**Subject:** 2025/62/93355/E Land off Woodward Court

## **OBJECTION TO PLANNING APPLICATION FOR ERECTION OF 75 RESIDENTIAL DWELLINGS WITH ASSOCIATED LANDSCAPING, OPEN SPACE, HIGHWAYS AND DRAINAGE INFRASTRUCTURE**

**LAND OFF, WOODWARD COURT, MIRFIELD, WF14 0PY**

**LPA REF: 2025/93355**

TITLE WELLHOUSE LANE/FLASH LANE  
EXISTING HIGHWAY LAYOUT

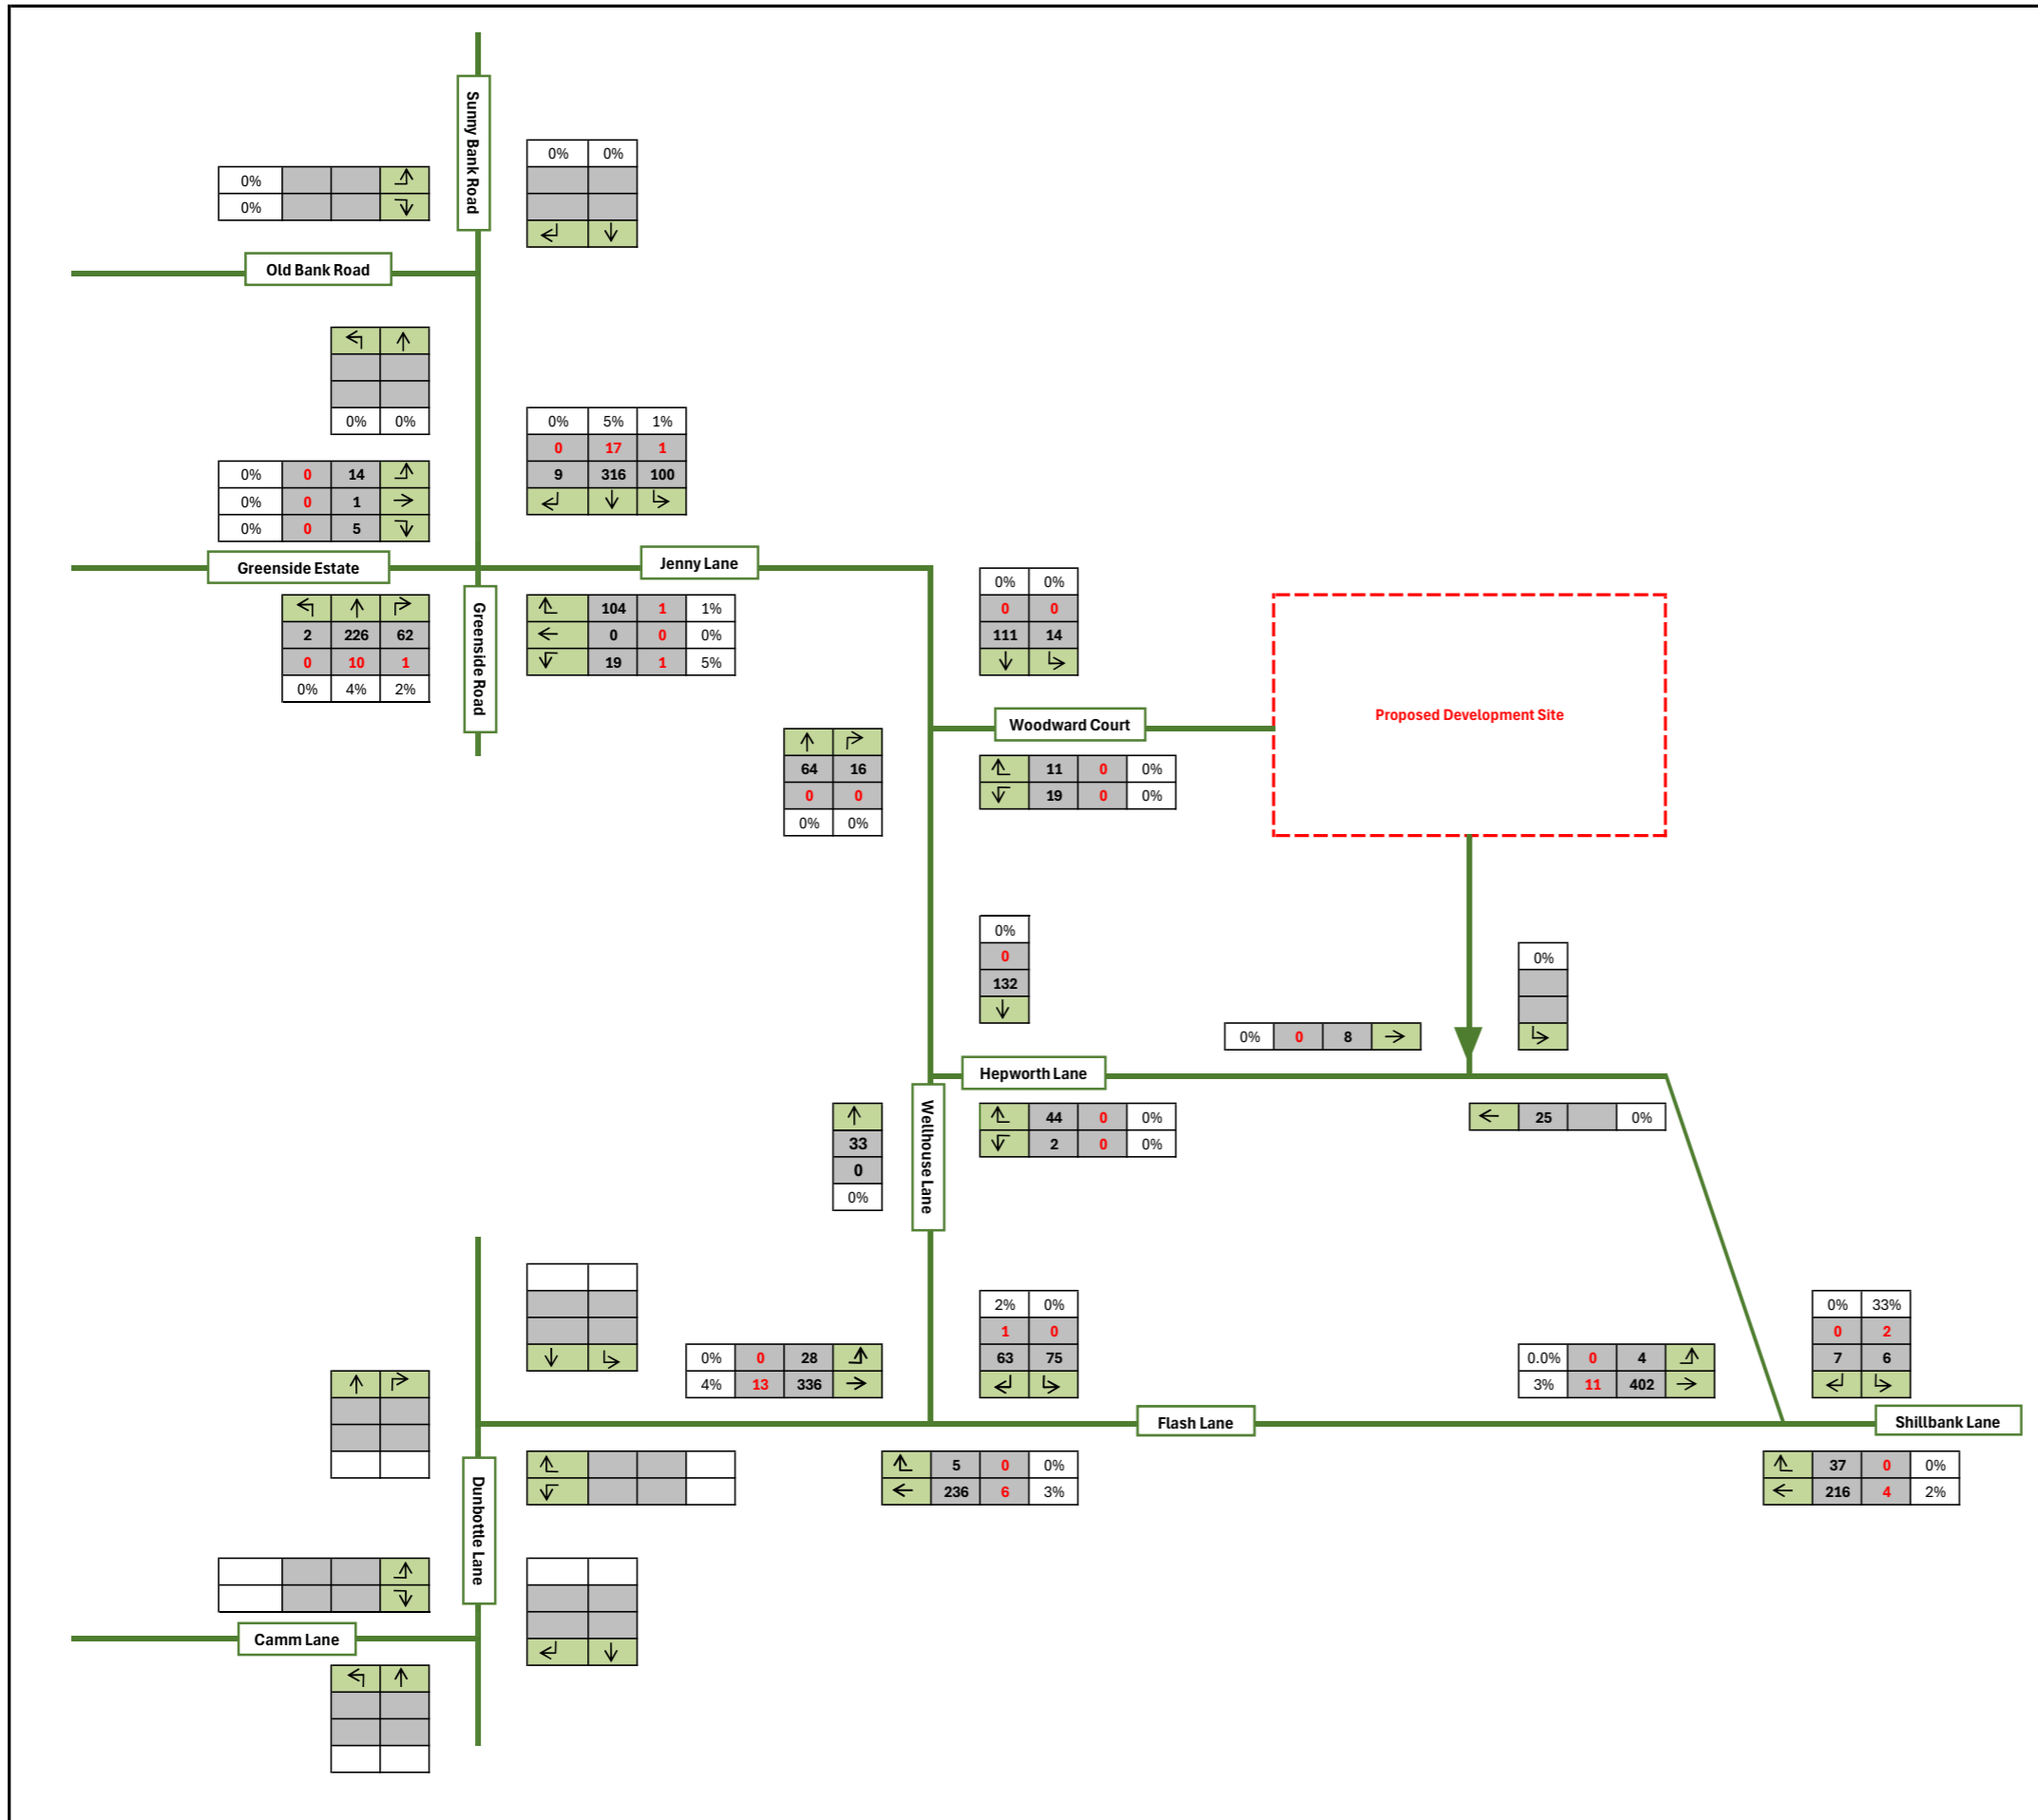
- b. *Wellhouse Lane / Flash Lane junction* The visibility exiting Wellhouse Lane onto Flash Lane is poor due to the surroundings and on-street residential parking on Flash Lane. Sanderson Associates (SA) suggest a footway widening on Flash Lane to increase visibility for drivers exiting Wellhouse Lane, but this should be judged against the presence of on-street parking, and eastbound vehicles on Flash Lane stopping here for oncoming traffic.

Adequate passing width therefore needs to be maintained. It would be difficult to introduce waiting restrictions here, as residents are likely to object.

**Response:** There are no proposals to mitigate or improve these identified highway deficiencies.
